NSW RURAL FIRE SERVICE

Your reference: SSD 8114
Our reference: D16/4083
DA16120105048 BB

Proposed Change of Use, Lindfield Learning Village (SSD 8114) – 100 Eton Road Lindfield

Figure 12 | APZ (Source: Supplementary RtS)

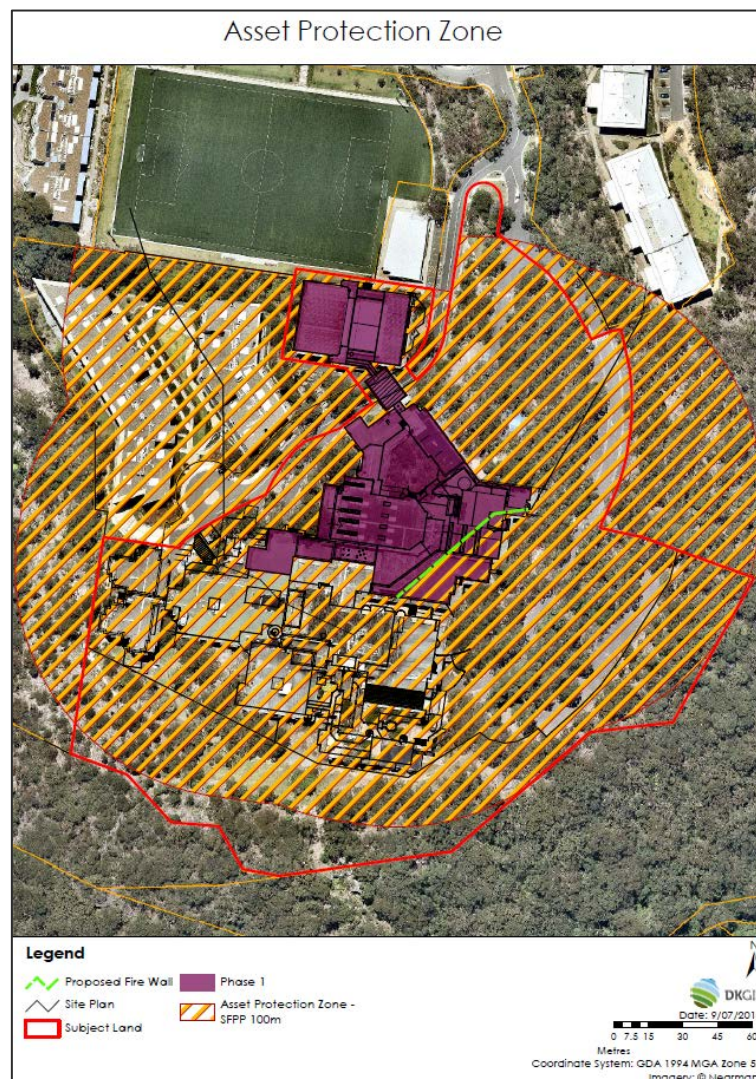
- Information that demonstrates how the proposed development complies with the minimum specifications for APZs for special fire protection propose (SFPP) developments as defined on Table A2.6 of PBP 2006.

Figure 14 | Location of propose fire trail (Source: Supplementary RtS)

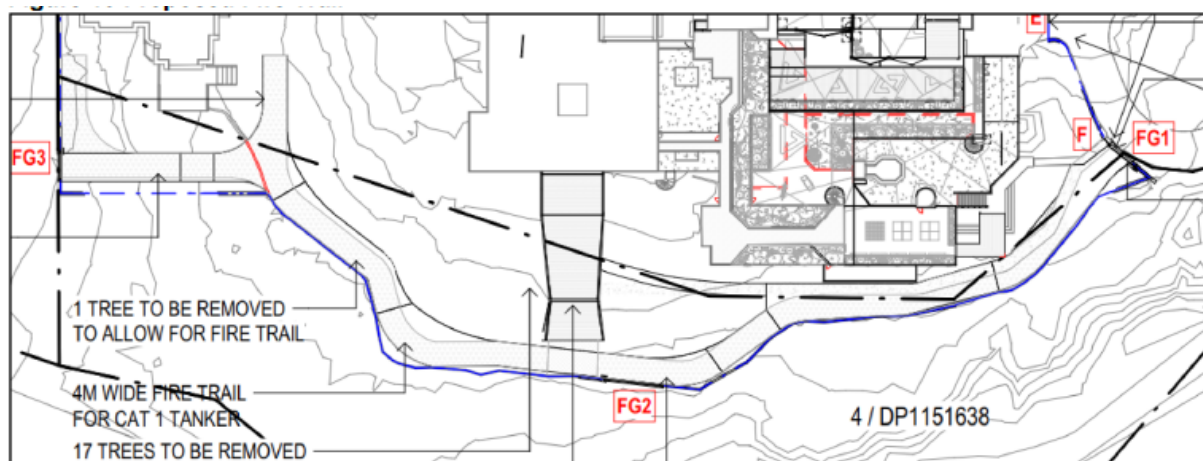
- Information that demonstrates how the proposed development complies with section 4.2.7 of PBP 2006 with regards to the provision of safe access arrangements.

- As noted in section of 4.2.7 of PBP 2006, the public road system in a bush fire prone area should provide alternative access or egress for firefighters and occupants during a bush fire emergency if part of the road system is cut by fire. This is of critical importance for areas with the higher densities associated with SFPP developments.
